Deadline 6 Submission

Planning Inspectorate Reference: EN010159 – One Earth Solar Farm

Date: 03/12/25

Figure 4.1: Barred Route Plan

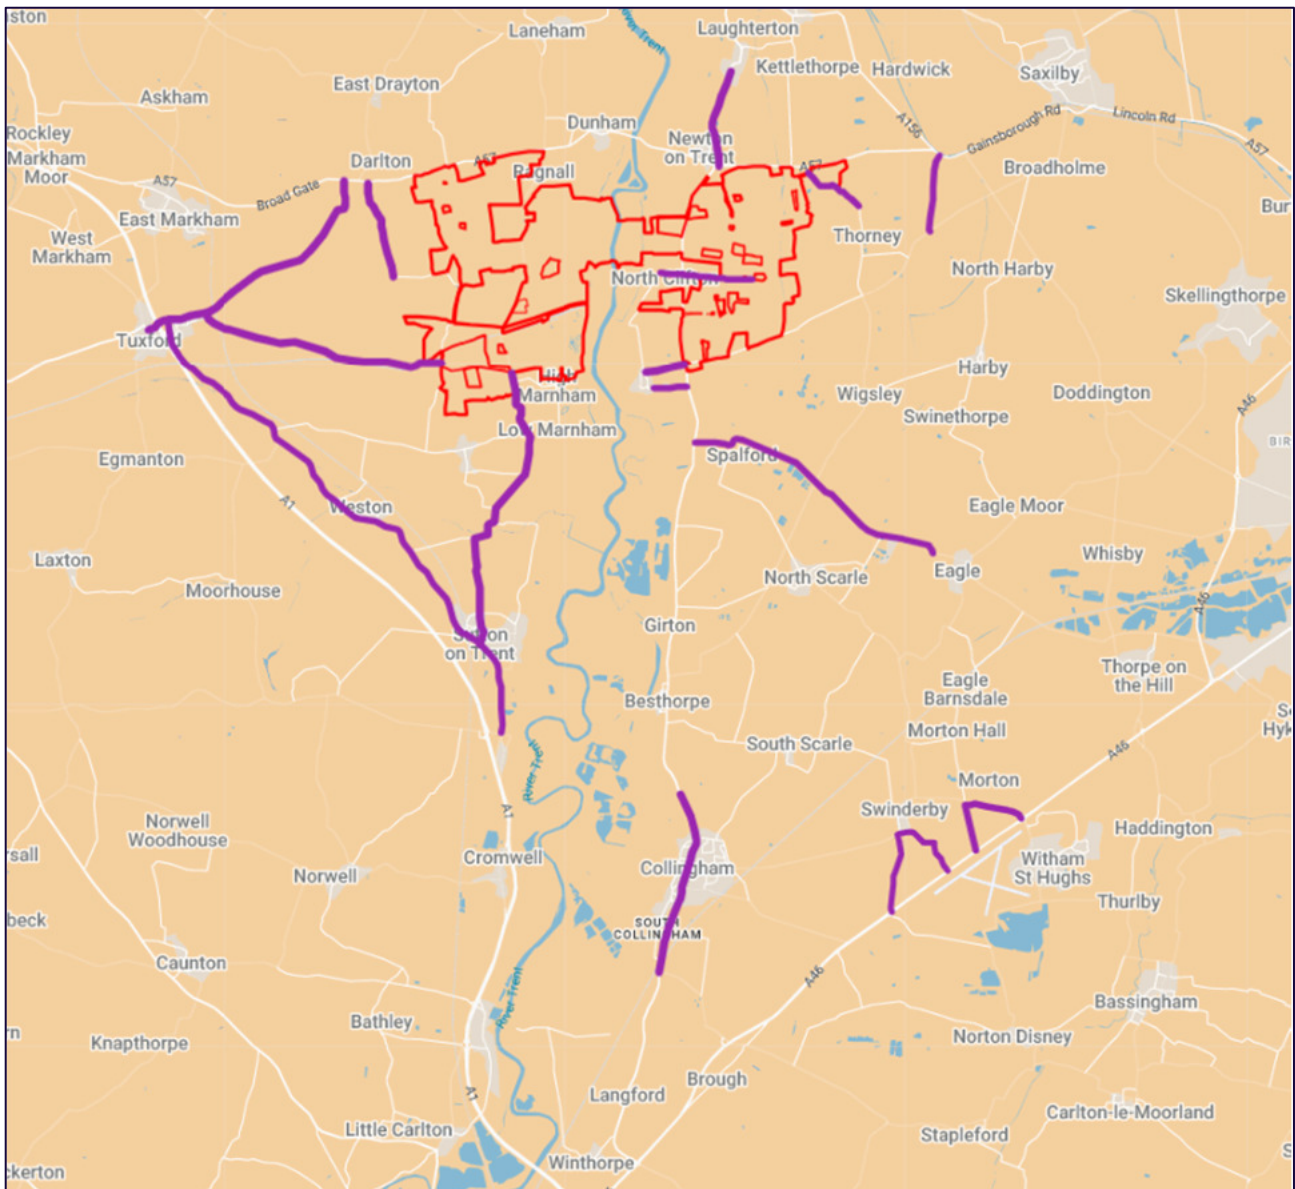
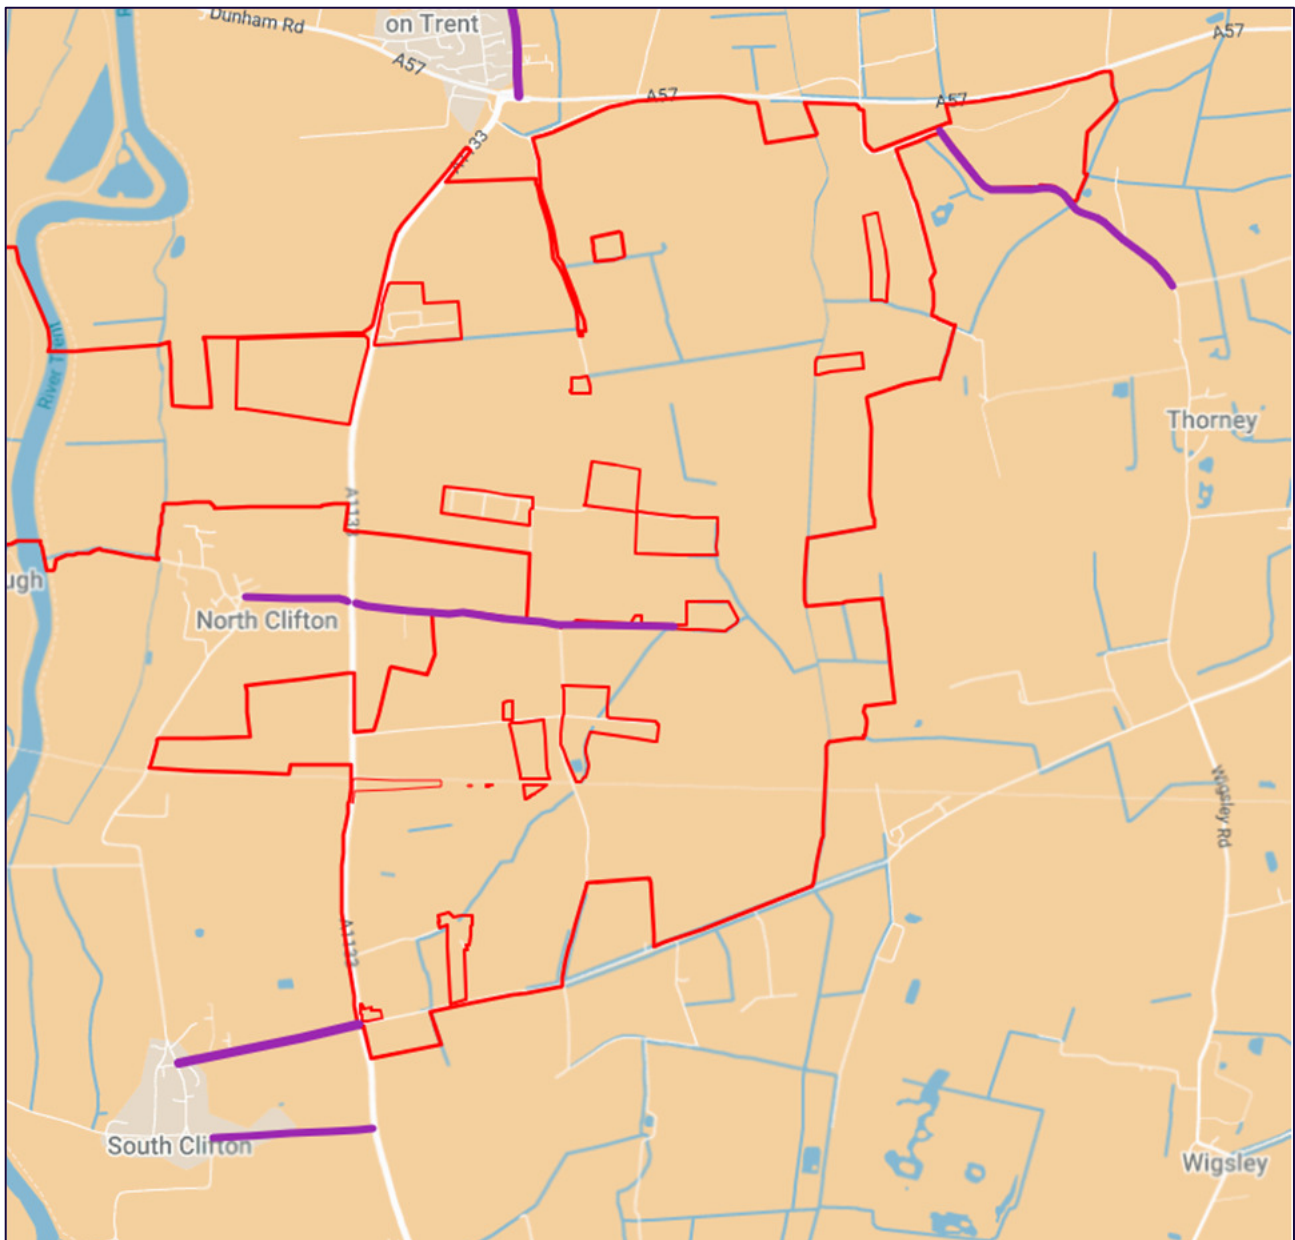
- Ambiguous road references (Moor Lane, Mill Lane, Trent Lane) where North Clifton and South Clifton have identically named but very different roads
- No sufficiently clear mapping of barred routes. Despite repeated community requests and discussions during hearings, the Outline CTMP does not identify Moor Lane as a prohibited construction route, nor is any schedule of restricted routes secured via the dDCO Requirements. Without an explicit barred-routes map, secured on the face of the DCO and in the CTMP, construction HGVs could legally use Moor Lane. The Parish Council therefore requests that the ExA require the Applicant to submit a certified “Barred Routes Plan” and to include Moor Lane as a legally restricted route within Requirement wording.
- Overreliance on official accident records despite extensive unrecorded near-misses reported locally

- Clear, village-specific road naming
- Definitive barred-route mapping
- Prohibition of construction traffic on Moor Lane (South Clifton), as stated above.
